**Consultation Response from KC,
Highways Development Management**

2022/93397 Highfields Centre, New North Road, Huddersfield, HD1 5LS

**Date Responded: 25/08/2023
Responding Officer: Ryan Kinder
Responding Ref:K5-5SE/6**

Scale	Sheet	Date	Drawn	Checked	Drawing Number	Revision
1:100	1/200	08.03.18	mjd	mjd	18.007(2)-001	0

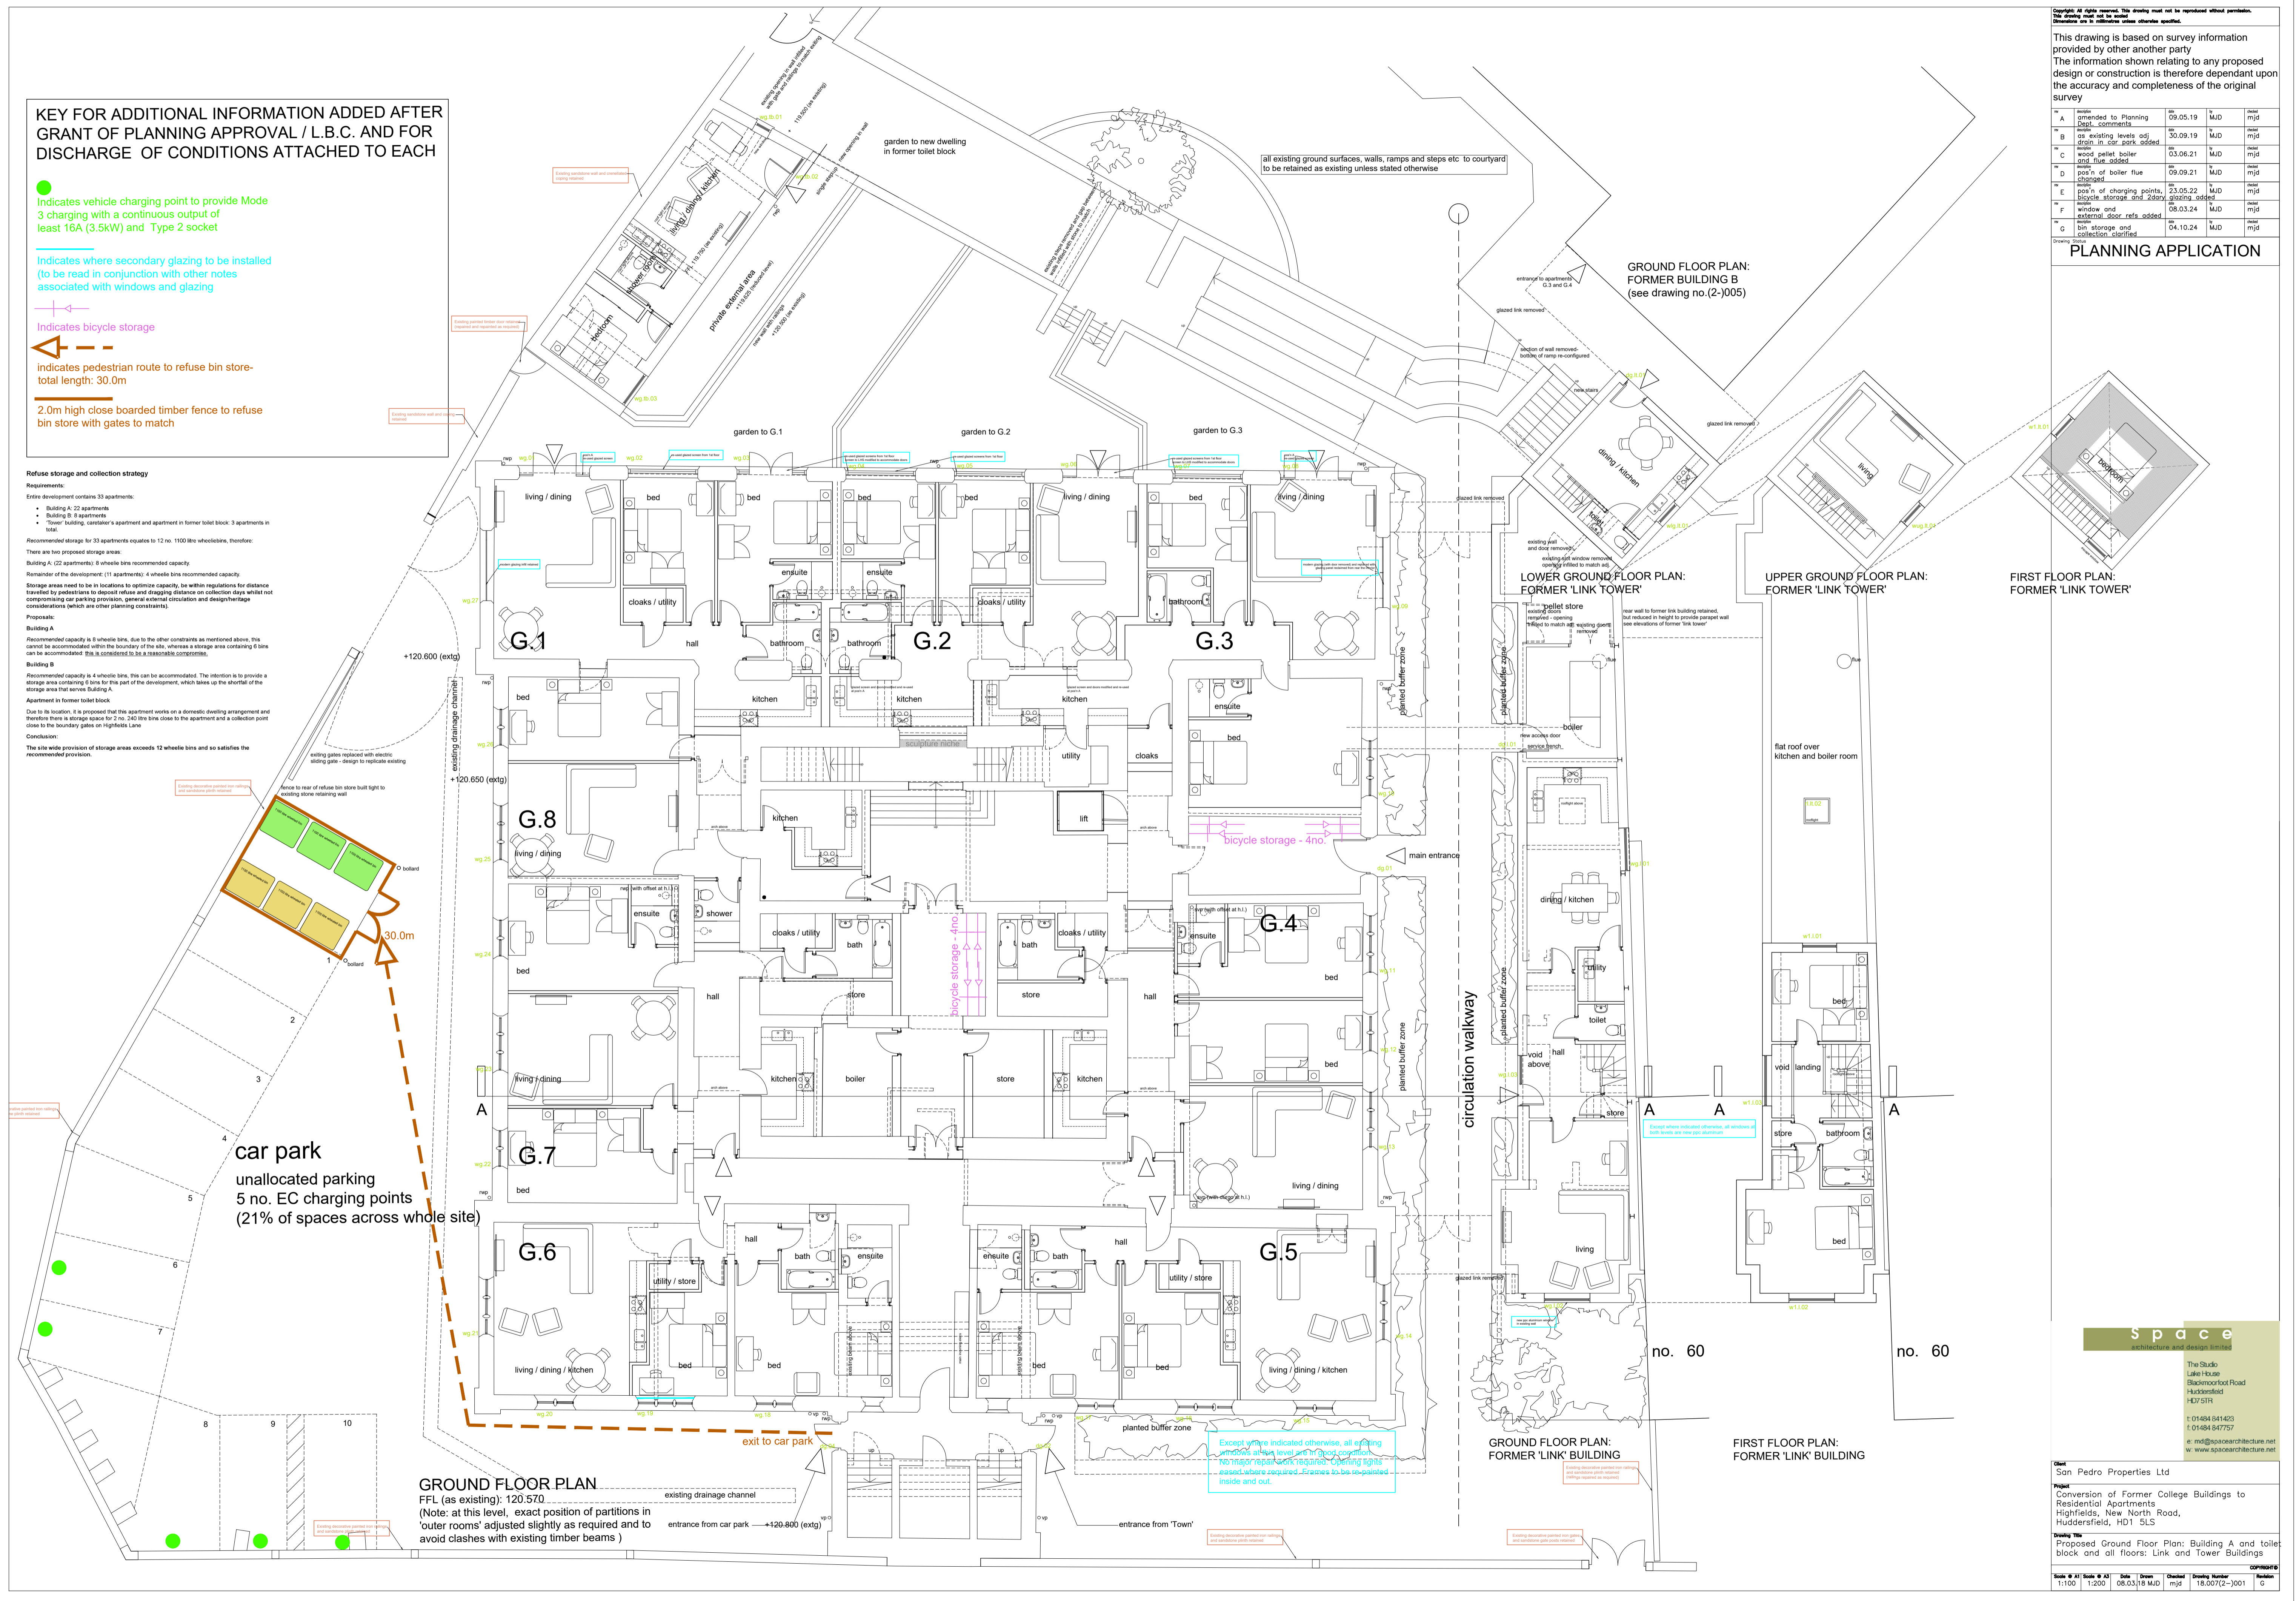
The submitted dwg ref (18.007(2-)001 dated 08.03 refers to the location of the cycle storage areas, there is no specific guidance on the overall level of cycle parking and 8 no spaced have been provided, given that consideration has been given to the provision then on balance this condition can be discharged accordingly.

Further to review of the conditions this application can only be part discharged, condition 3 provides insufficient information and therefore cannot be discharged. Condition 4 is considered acceptable and can be discharged accordingly.
